**Moorebank Precinct West (MPW) Stage 2 (SSD 7709) Response to Submissions**

**SSD16-7709**

## **ATTACHMENT A – RESPONSE TO ISSUES RAISED IN NSW DP&E SUBMISSION**

## MPW STAGE 2 SUBMISSIONS: DP&E KEY ISSUES - 16 DECEMBER 2016

Title
CIVIL WORKS PLAN SHEET 1

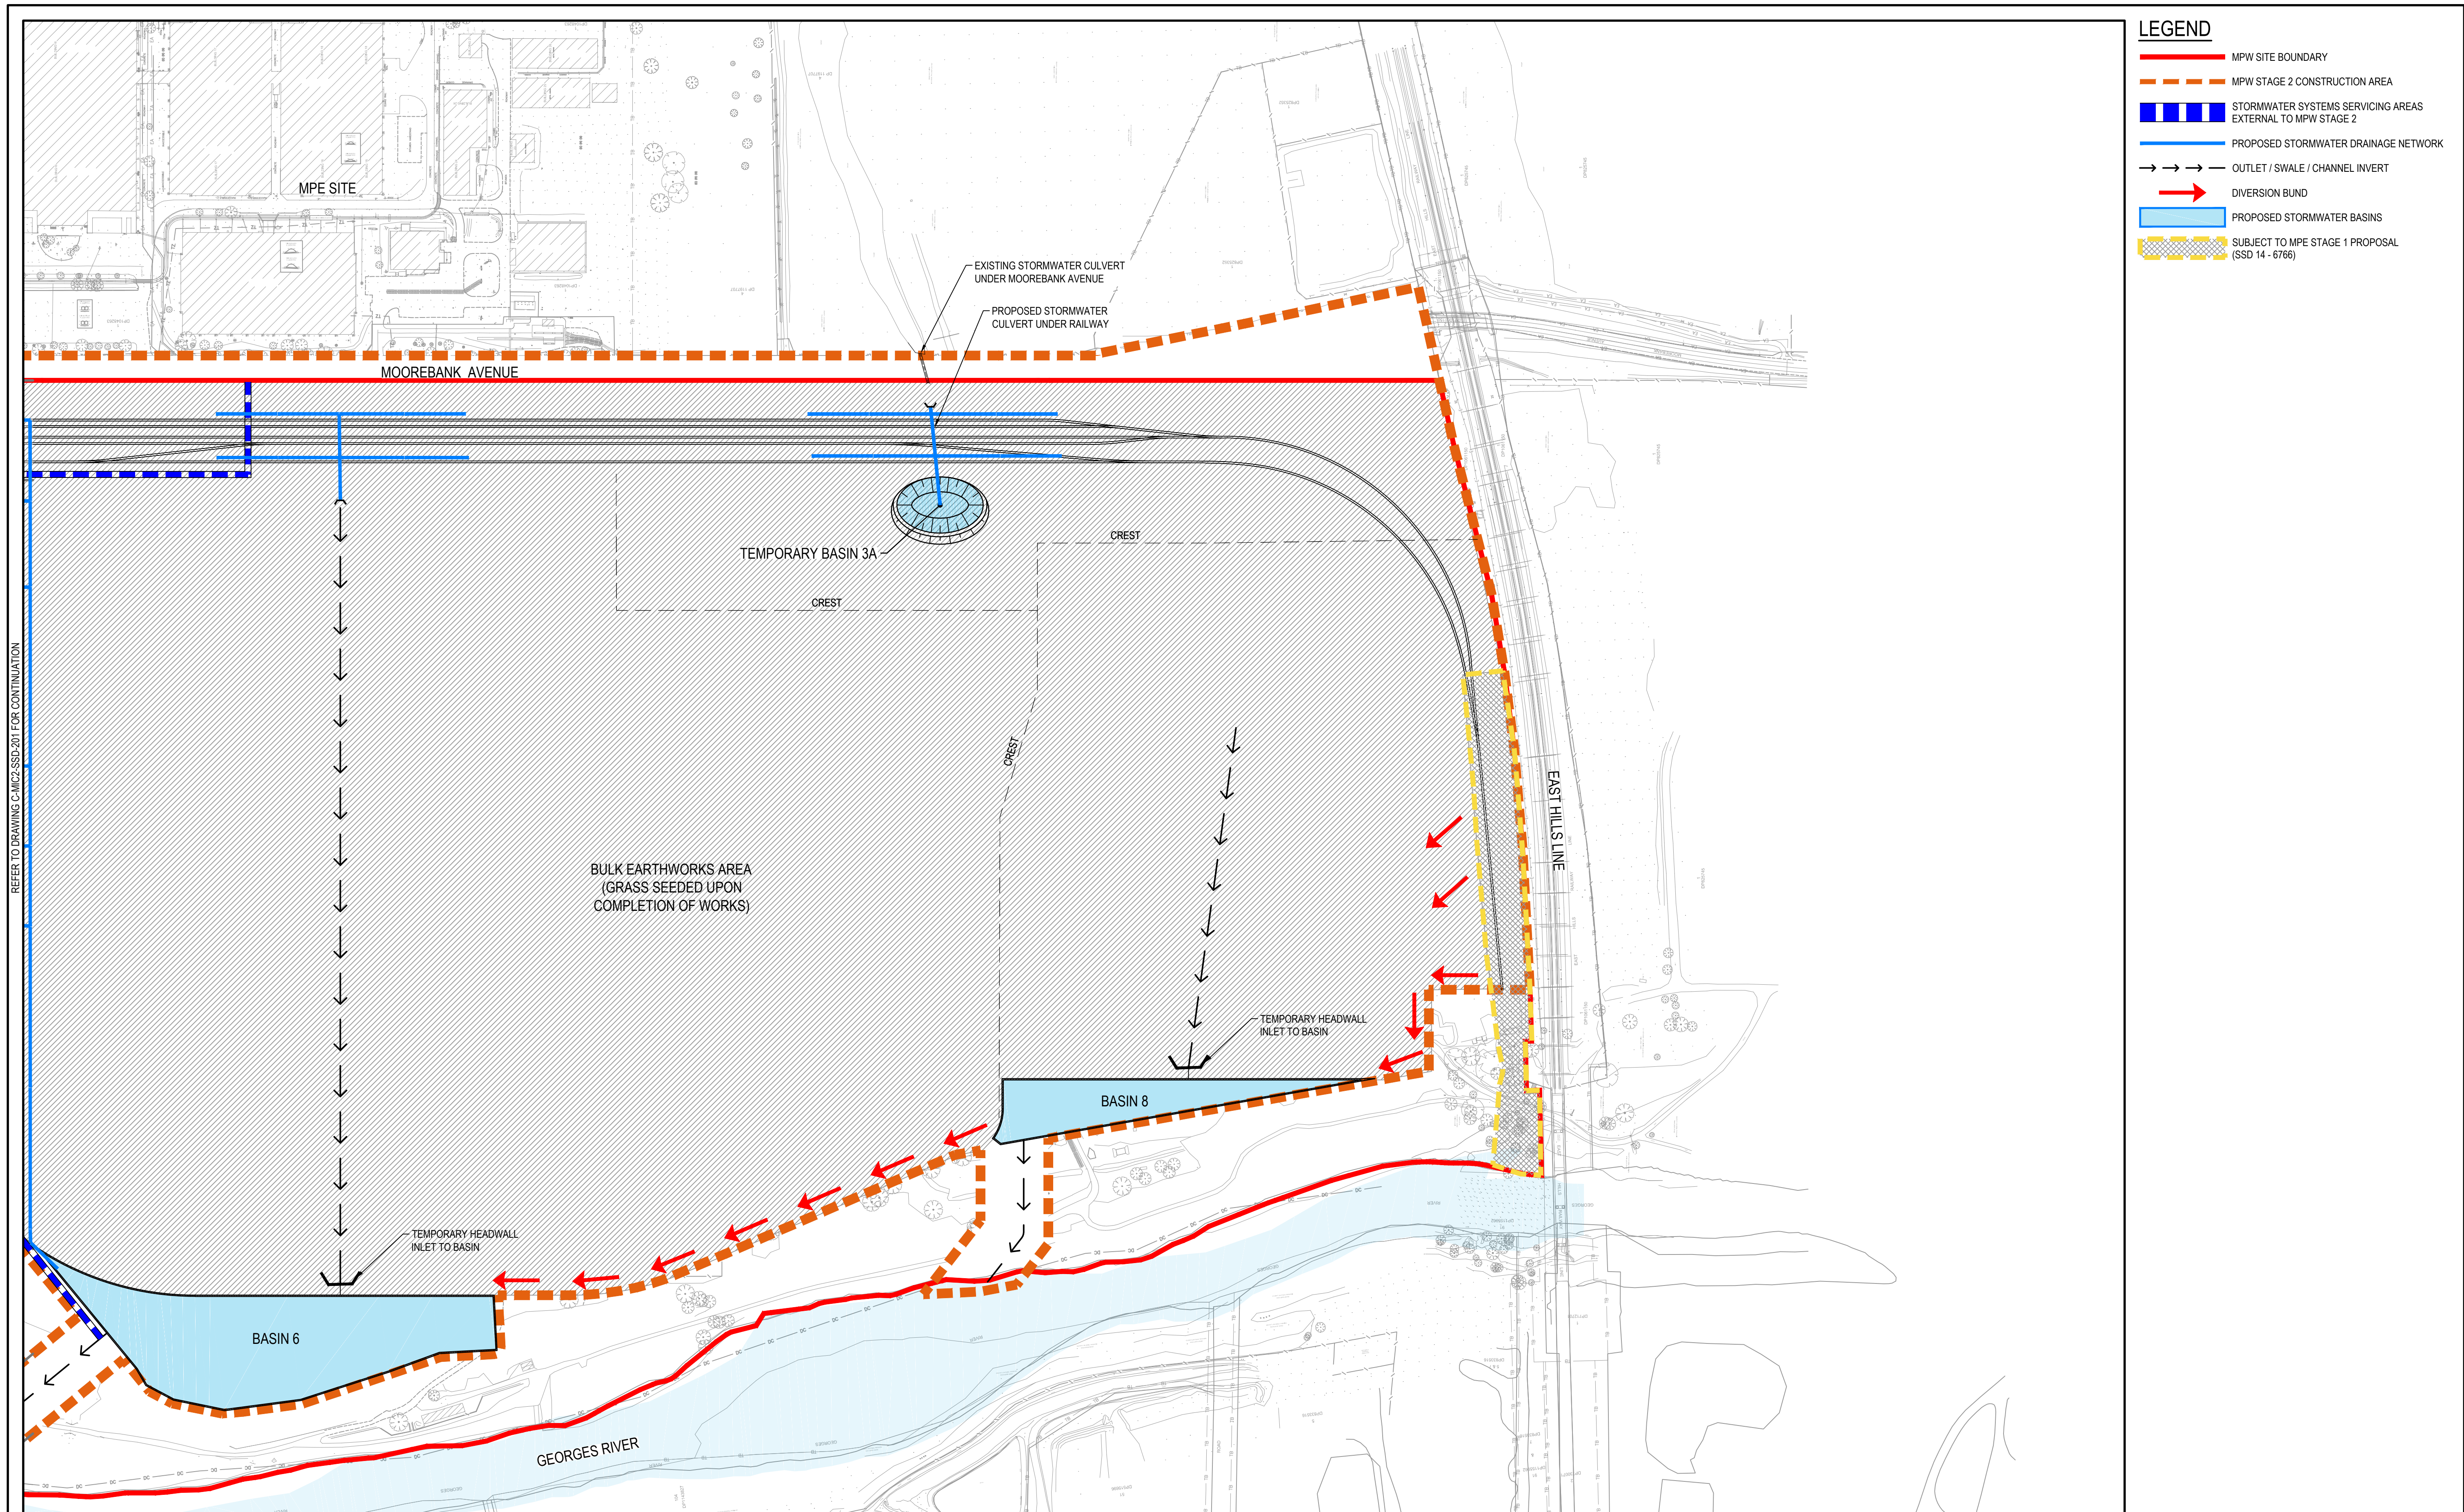
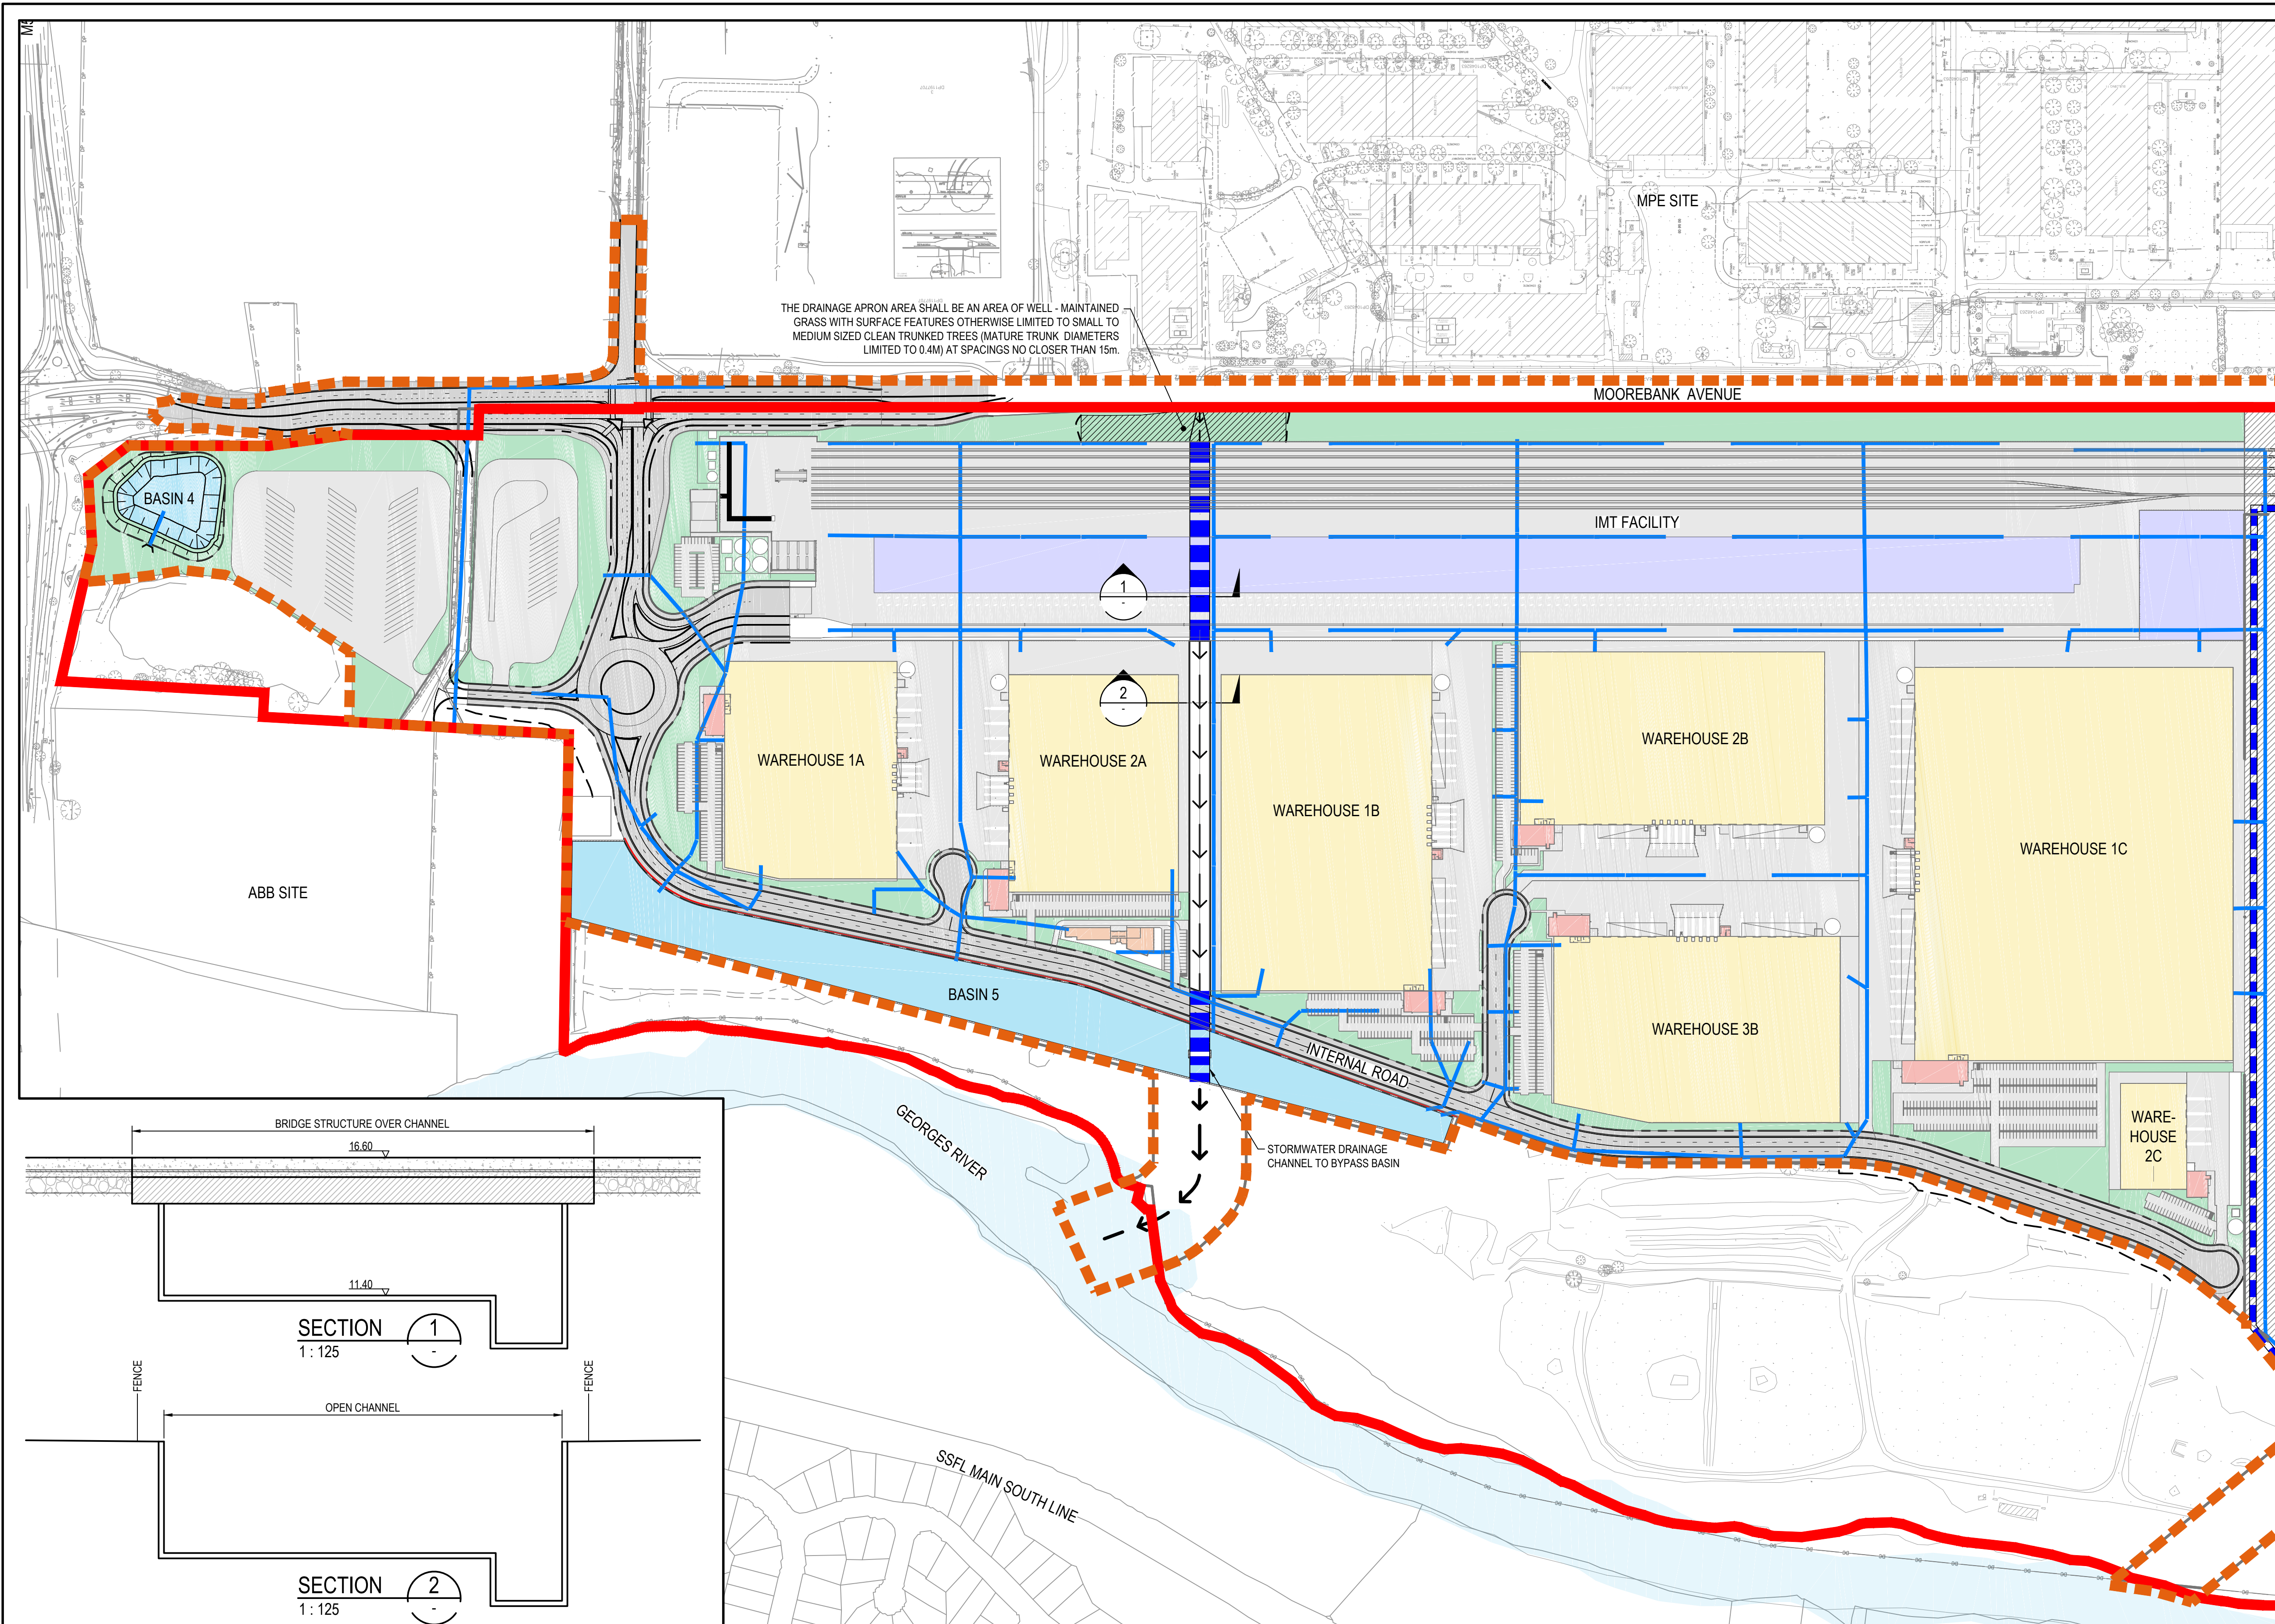
Cross-sections	<p>The civil works cross-sections indicate fill up to 4 m adjacent to the conservation zone as well as vertical walls to basins 5 and 6 and a vertical profile to the north of Basin 8. The landscape drawings in Appendix E only indicate bank treatments and treatment of the basin outlet channel adjacent to the Stage 2 warehousing. Drawings, including landscape plans, are to be provided for the entire area impacted by Stage 2 earthworks including details on retaining structures, bank slopes and stabilisation adjacent to the conservation zone.</p>	<p>Revised landscape drawings in accordance with Proposal Amendments are provided in Appendix B of the MPW Stage 2 RtS. Bank stabilisation methods provided in revised Landscape Plans (refer to Appendix B of the MPW Stage 2 RtS) for Basin 5 includes the planting of native vegetation appropriate to the fluctuating hydrology and provenance of the area, and potential provision of an eco-blanket to assist in stabilisation and seed germination. These designs are typical of stabilisation works elsewhere within the conservation area as part of the Proposal.</p>	Appendix B of the MPW Stage 2 RtS
